August 9, 2013

**Subject: Proposed Truck Loading Area – 56 Milliken Street  
Application ID: 2013-181  
Comments from City of Portland Staff**

FST has received your memos and reviewed the comments (*italicized*) on the above referenced project. Your comments (*italicized*) and our responses (**bold**) are as follows:

(L) 4'-0" PRECAST CATCH BASIN
N.T.S.

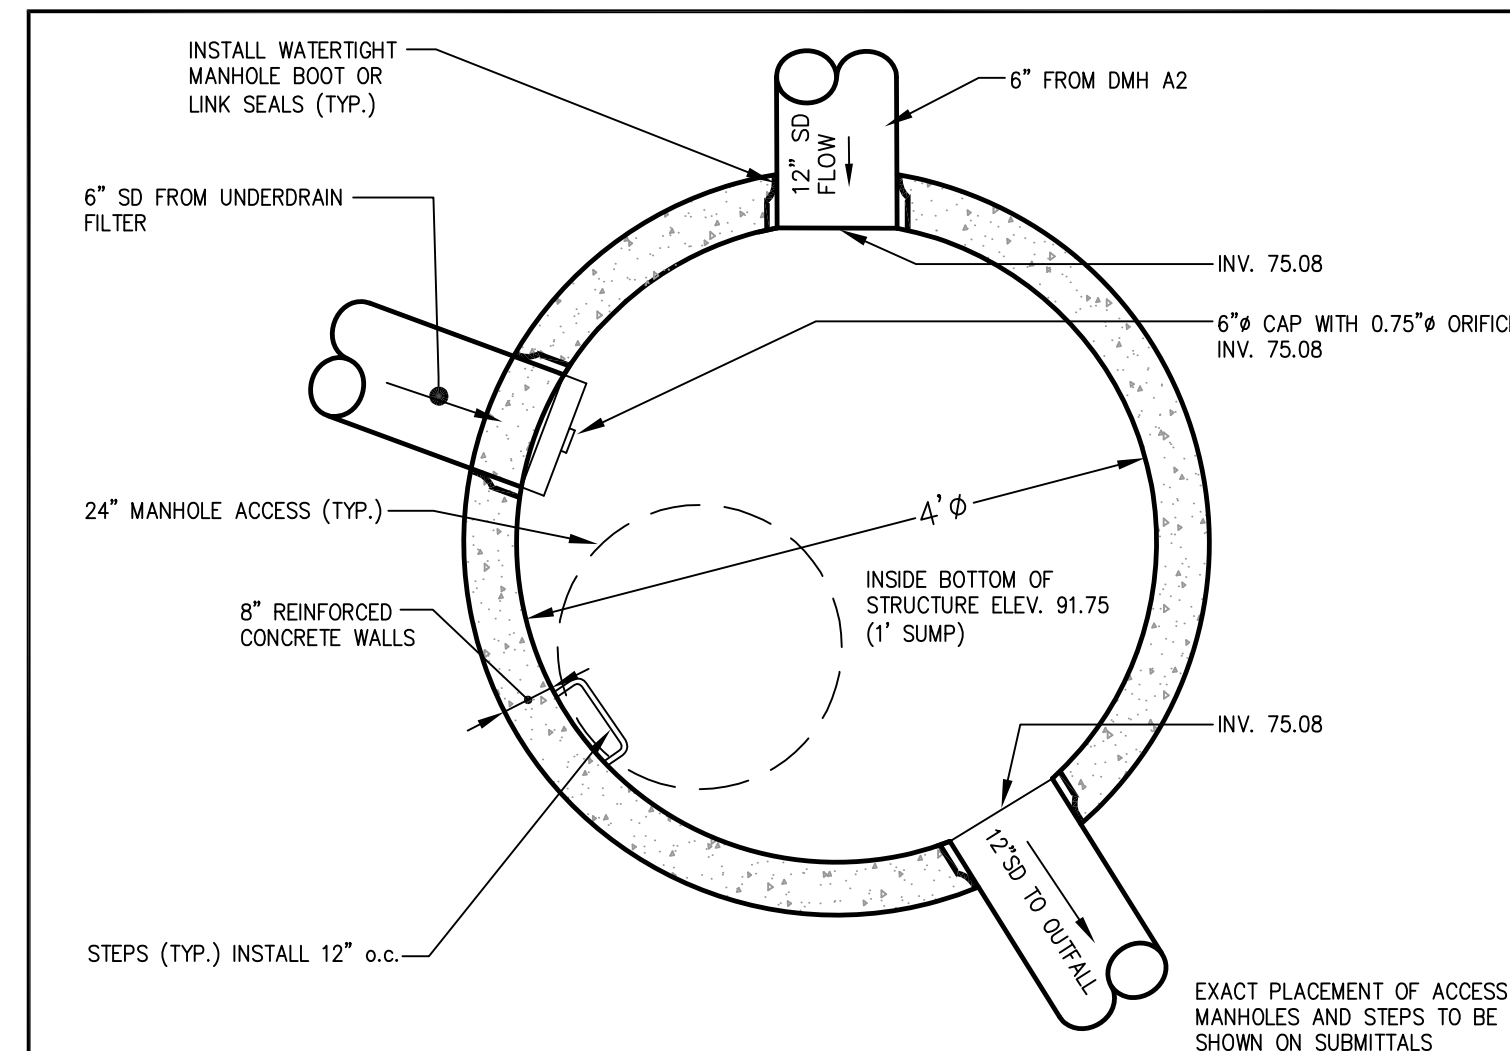
*Proposed catch basins require three foot sumps.*

5) The Applicant should provide a proposed catch basin detail

**The catch basin detail has been added to Sheet C-6.2 and it calls for a 3' sump.**

**A catch basin detail has been added to Sheet C-6.2.**
